**Department of Transportation**

November 20, 2020

RE: Trails at Aspen Ridge\_Legacy Hills Rd. / Bradley Rd. (Springs East at Waterview) - **SIGNAL review of construction drawings.**

BRADLEY ROAD / LEGACY HILL DRIVE ROAD & SIGNAL PLANS		
SIGNAL POLE & CONDUIT PLAN		
Subset: SG	Subset Sheets: 3 of 4	Sheet No: 3

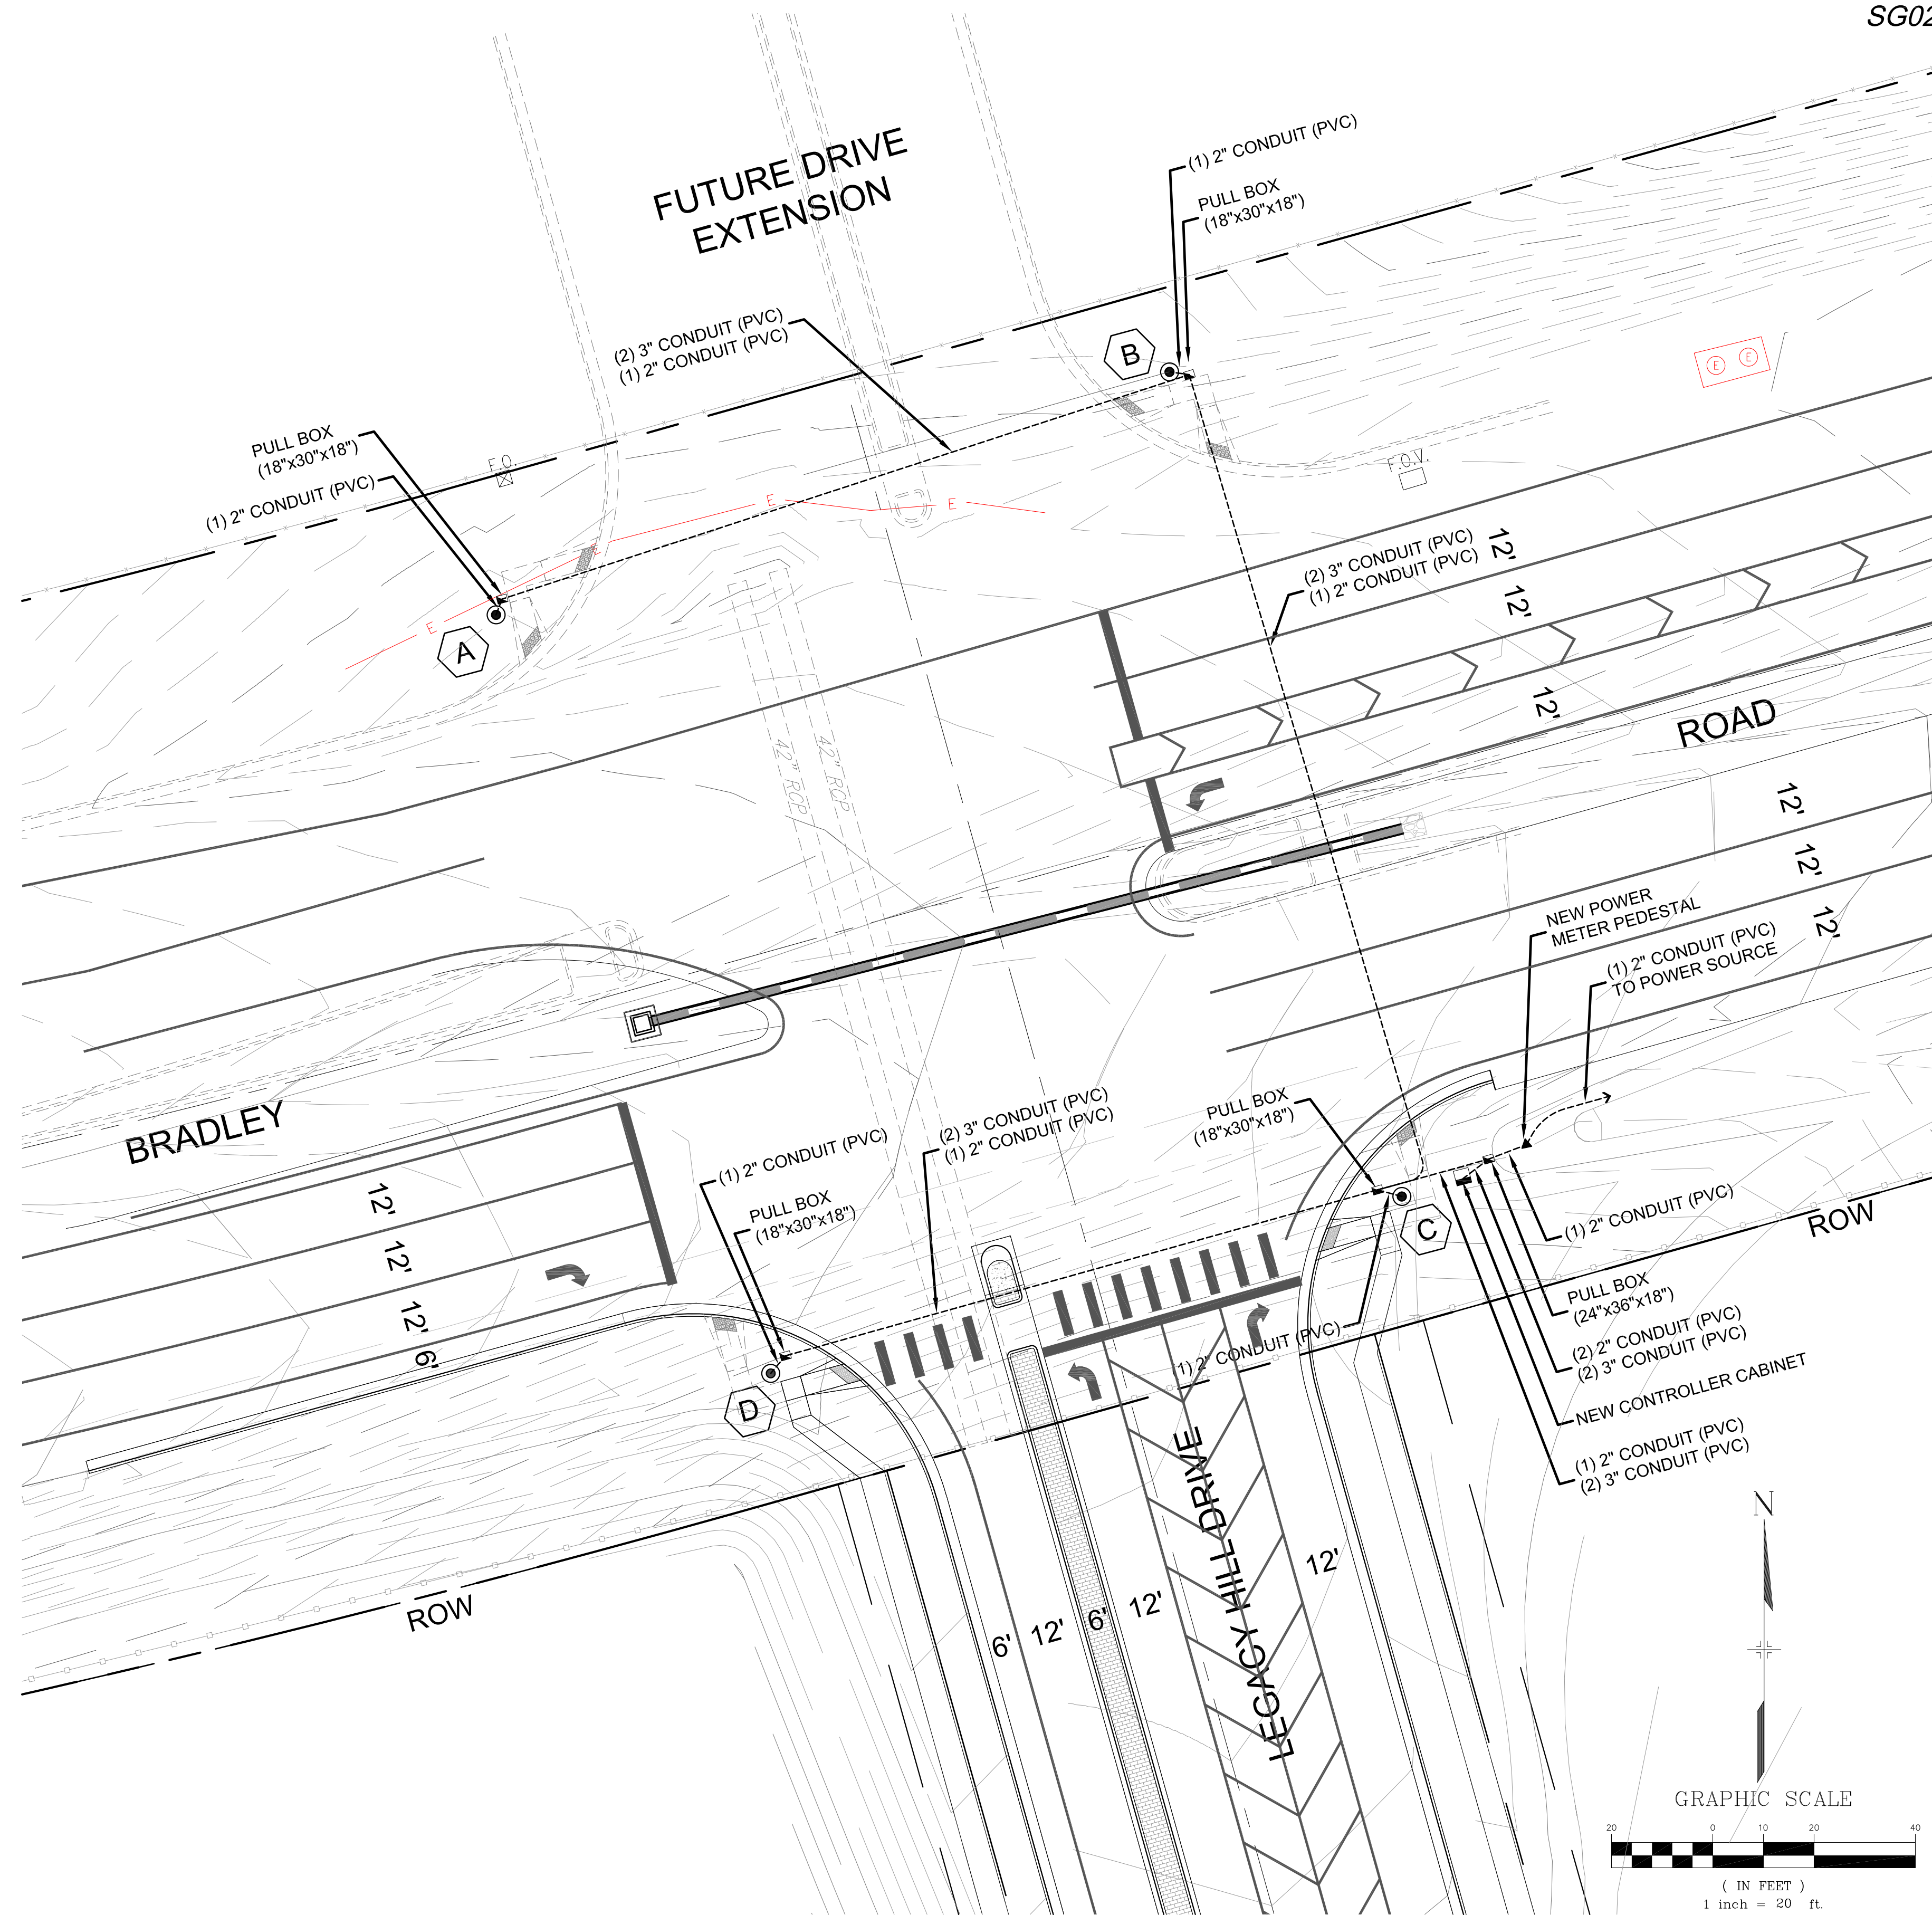
- a. Over the past several years, CDOT has made multiple comments regarding the spacing between SH21 and this proposed signal - comments have essentially been dismissed. While I understand that this location of the proposed signal is barely beyond the minimum 550' from SH21, in the future Bradley and Powers will eventually become an interchange. It is highly likely that the proposed location will be within the functional area of the the interchange requiring modifications and possibly the removal of full movement access to Legacy Hills Rd north and south to this development. I do not see the need to push the spacing so tight as this is virgin ground. CDOT requests, again, that the signal be shifted east along Bradely (approximately 750') to avoid future access modifications.
